LIBERTY TREE ACADEMY CONSTRUCTION DOCUMENTS

TOWN OF PEYTON, EL PASO COUNTY

PRELIMINARY DESIGN

MAY 2018

SPILLWAY SECTION (C)
SCALE: 1" = 5'

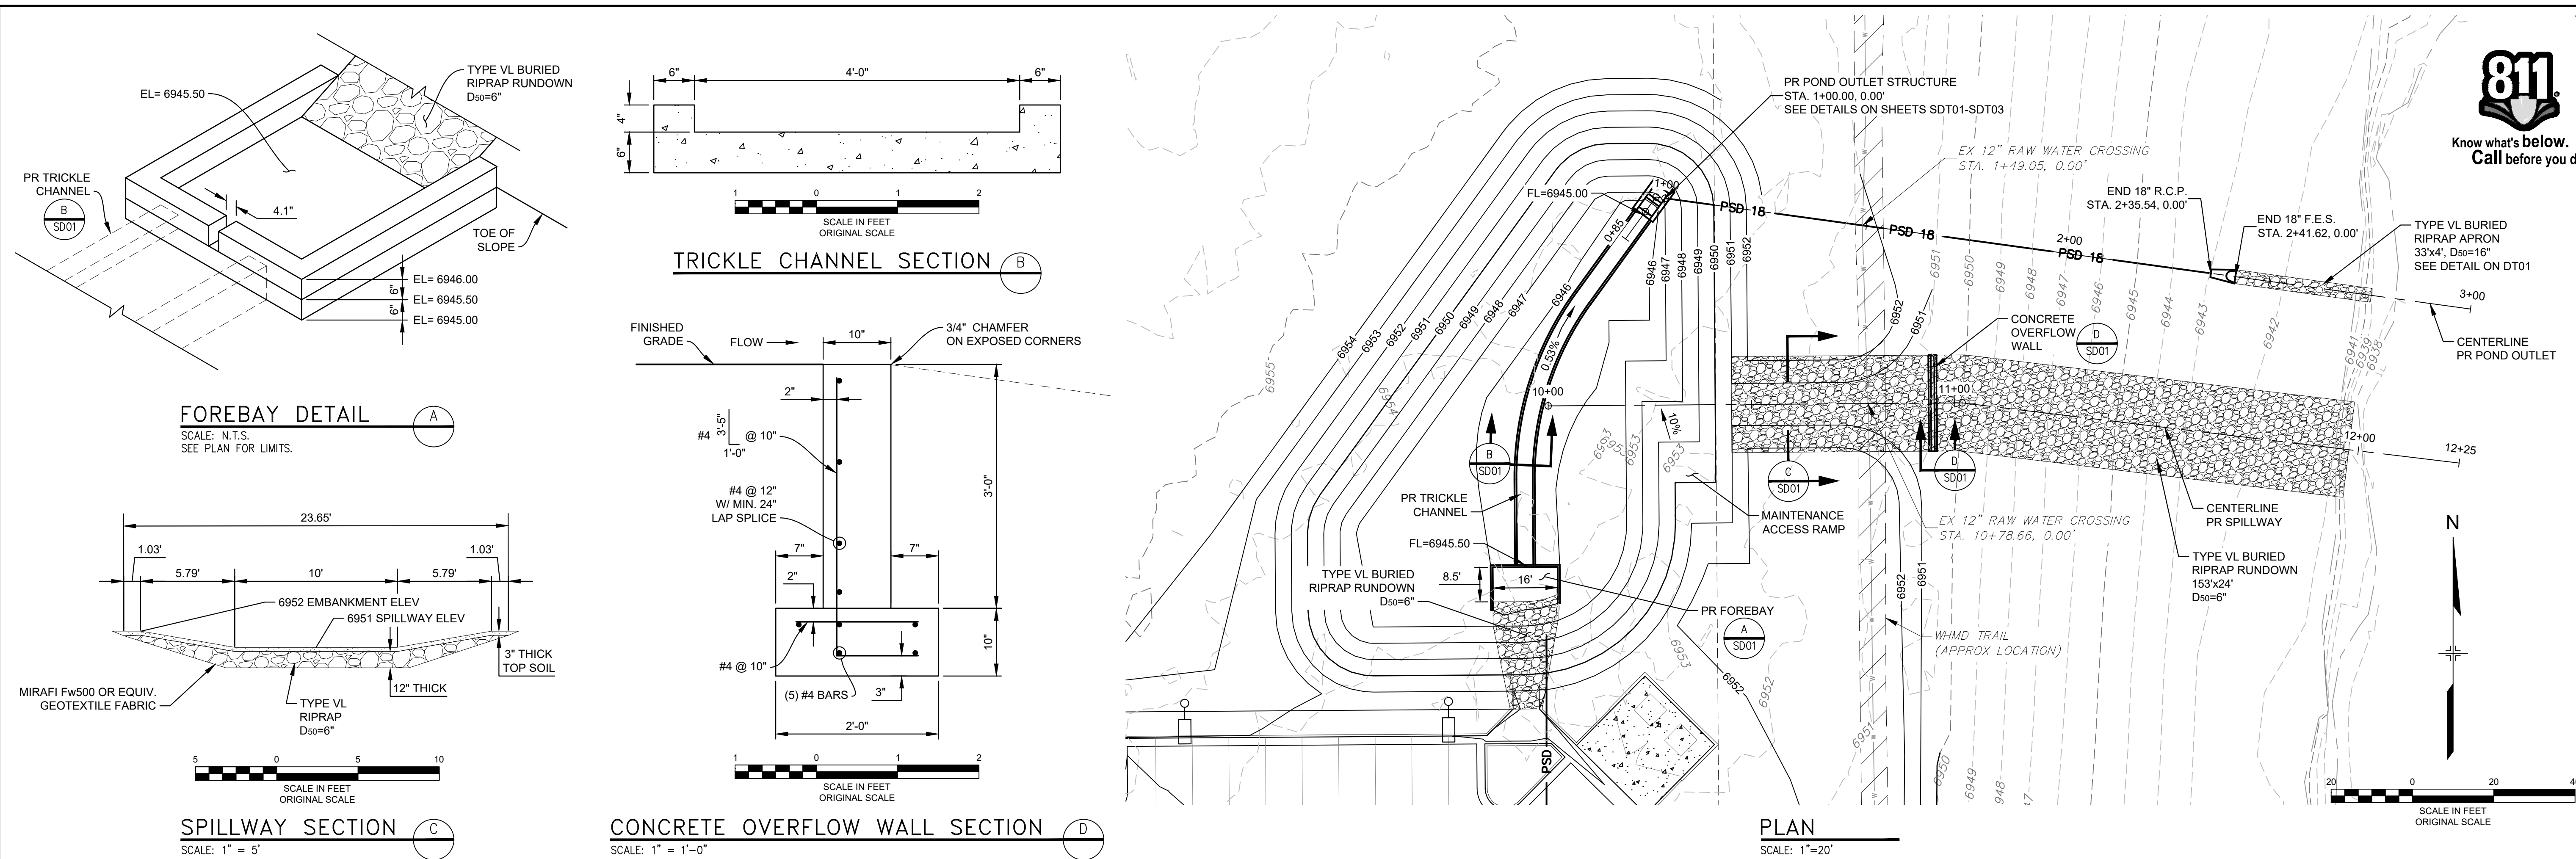
If this is a spillway show type of erosion protection.

| STORMWATER PLAN & PROFILE | | | |

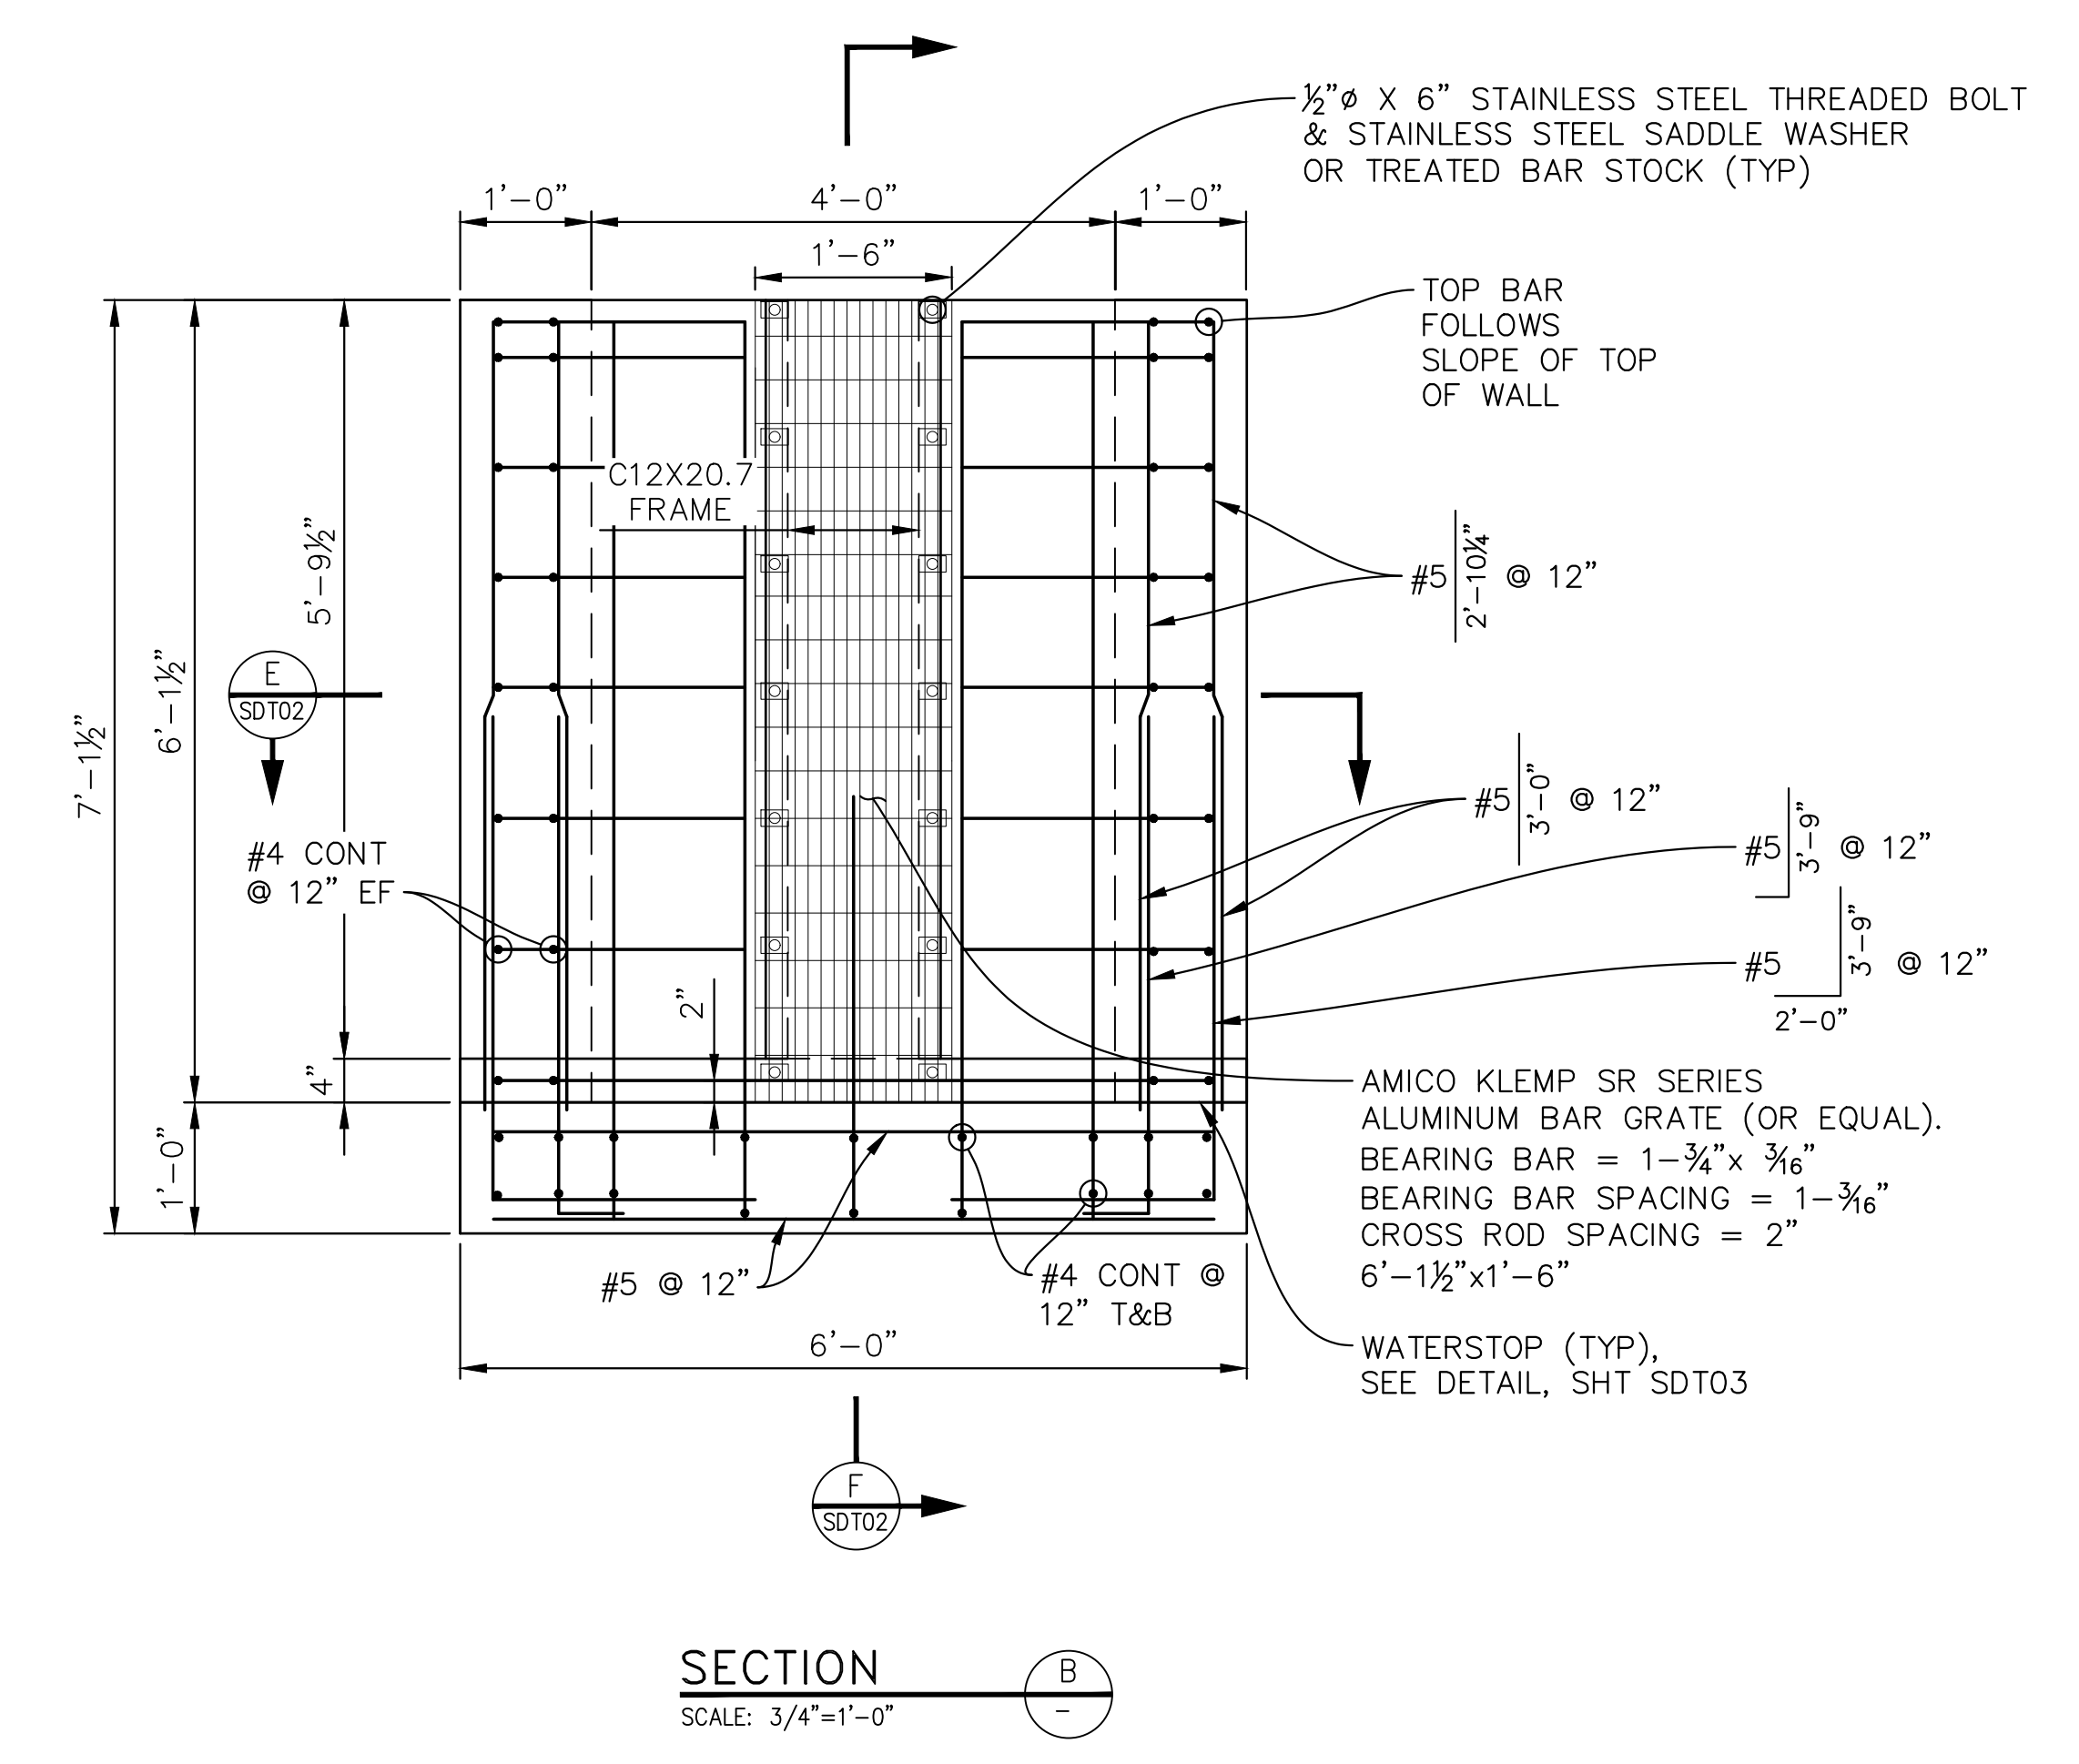
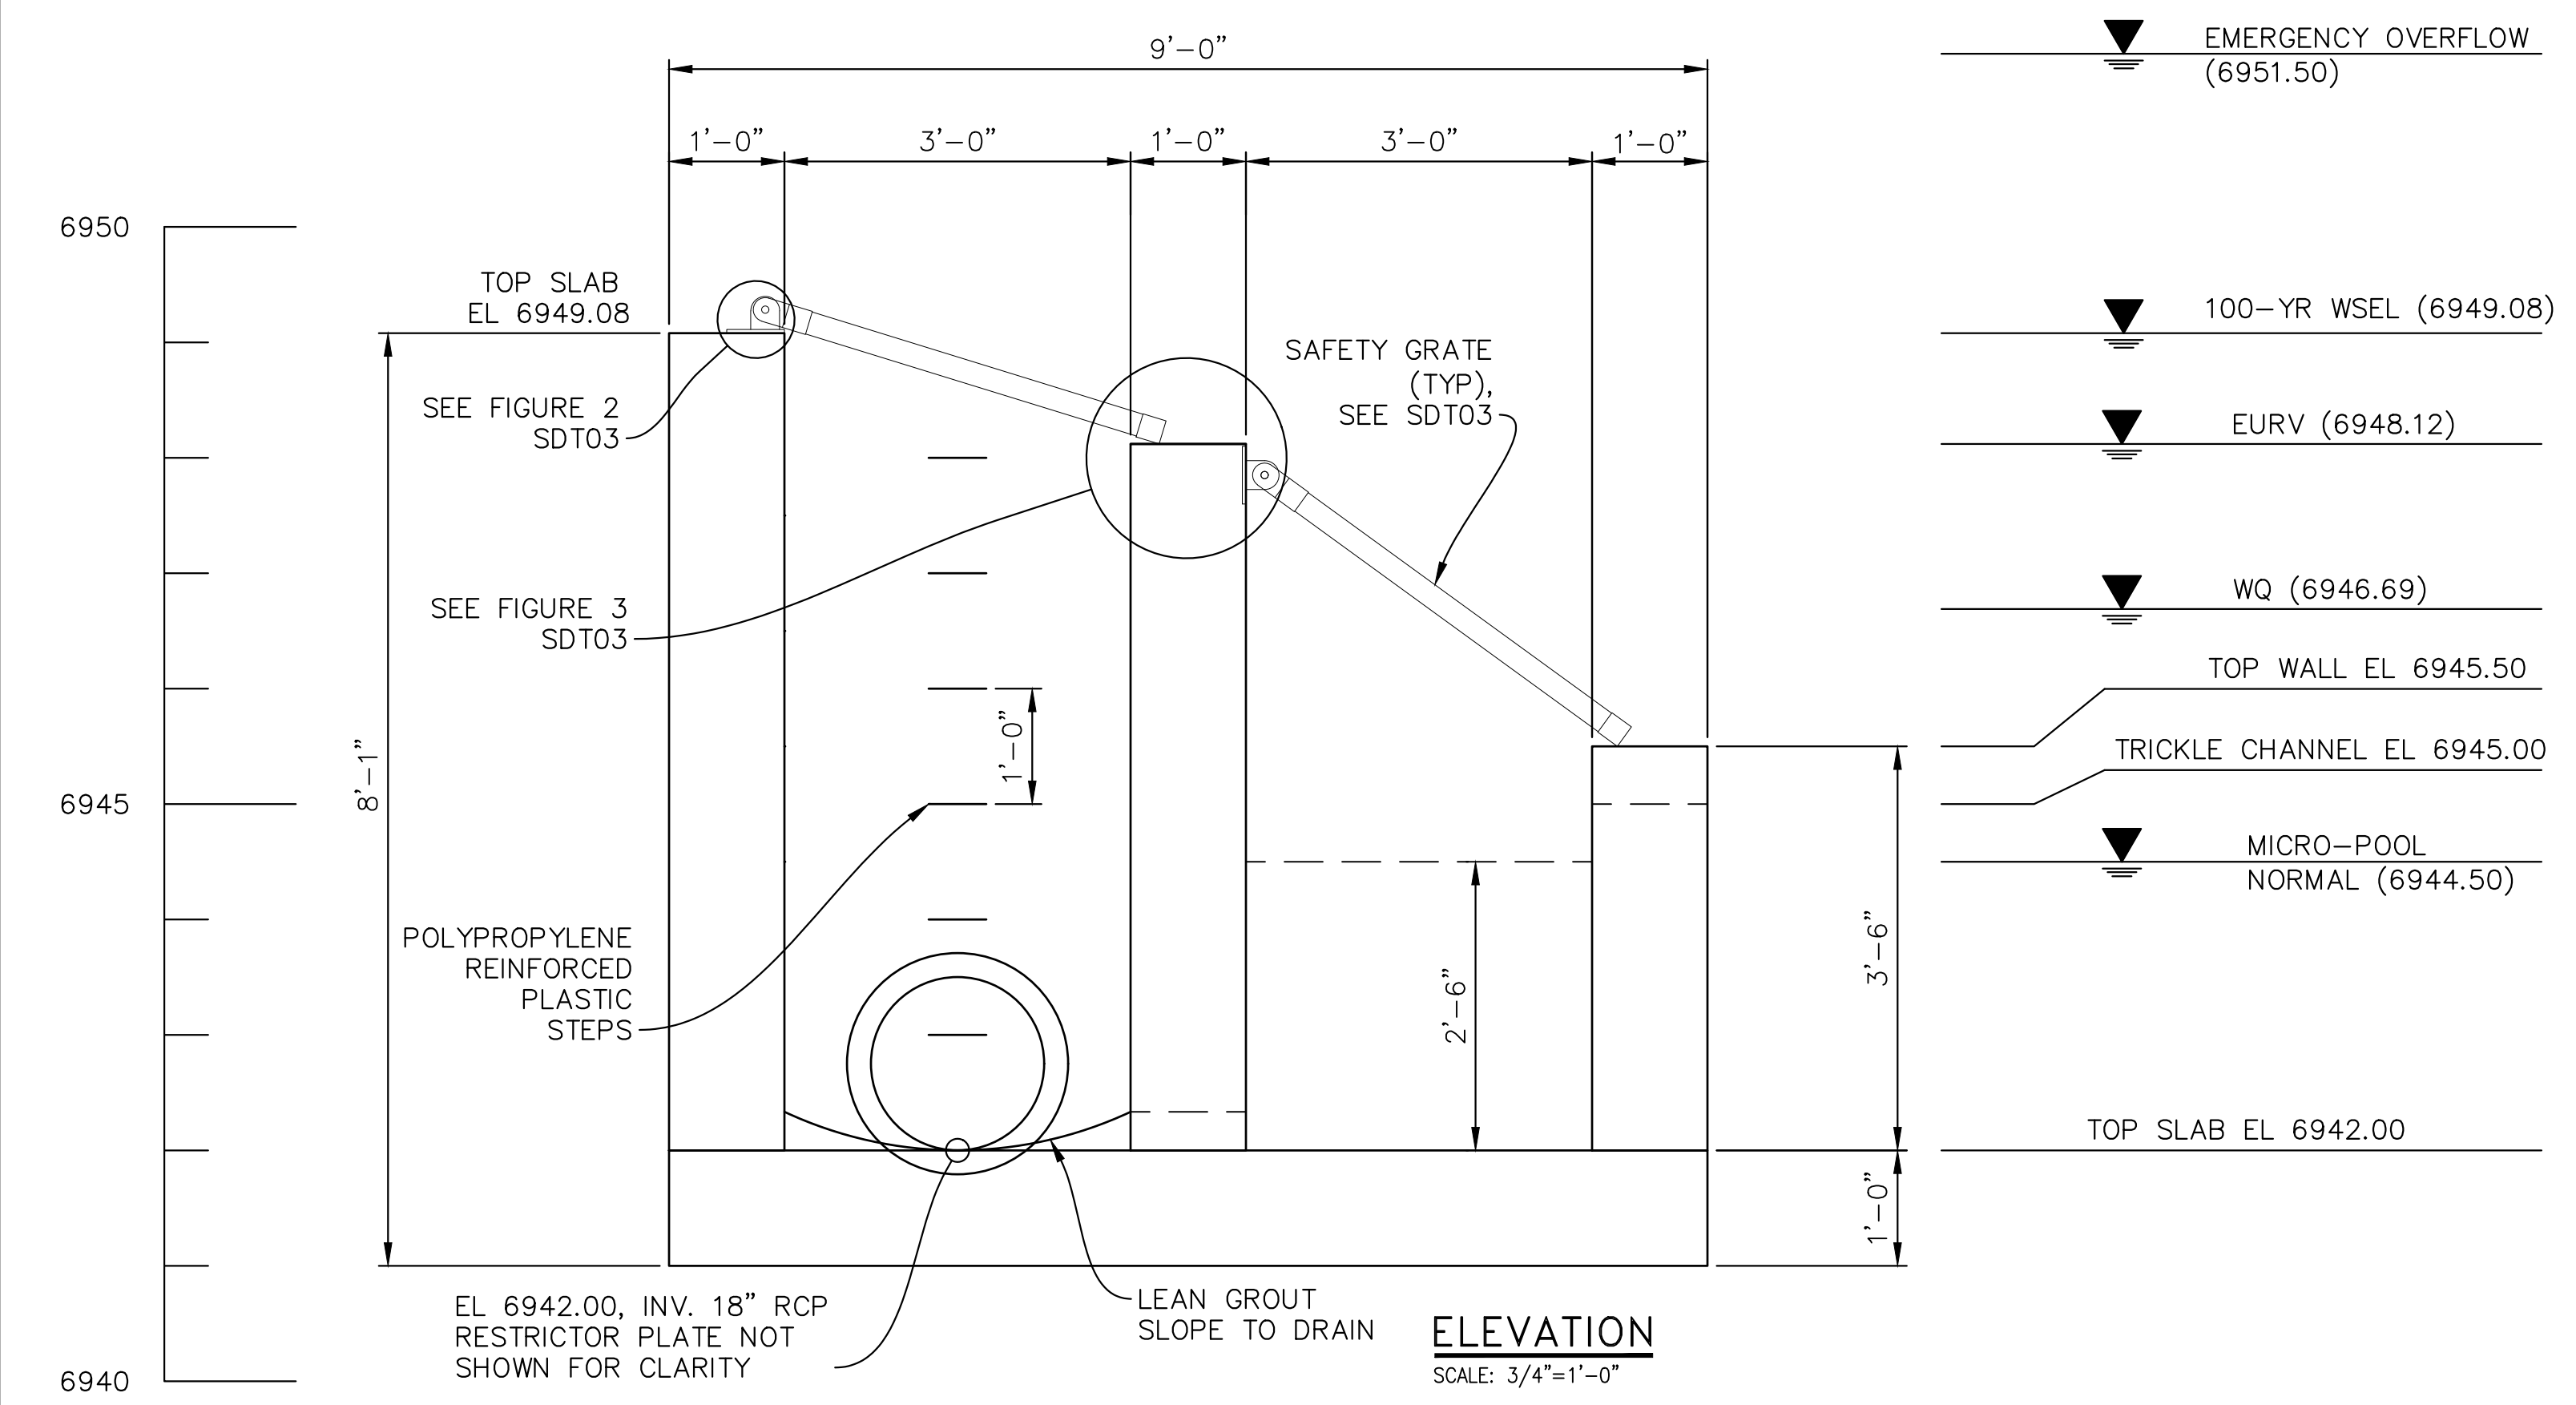
Pipe doesn't match. Address outfall protection.
